From: Iqraa Malik
Sent: 20 April 2022 10:06
To: Sian Eggington
Subject: FW: Request for further information M/38/22/HH
Attachments: Scan 19 Apr 2022 (1).pdf

BLOCK PLAN 1:500

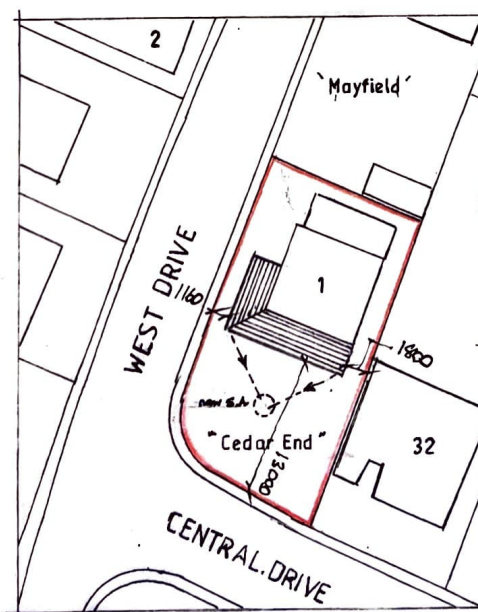
This application is still invalid as the location plan requires a solid red outline around the site boundary and the dimensions are still missing from the block plan. Please review and amend.

The dimensions to the boundaries were shown on the proposed ground floor plan submitted but I have also indicated these on the block plan for clarity.
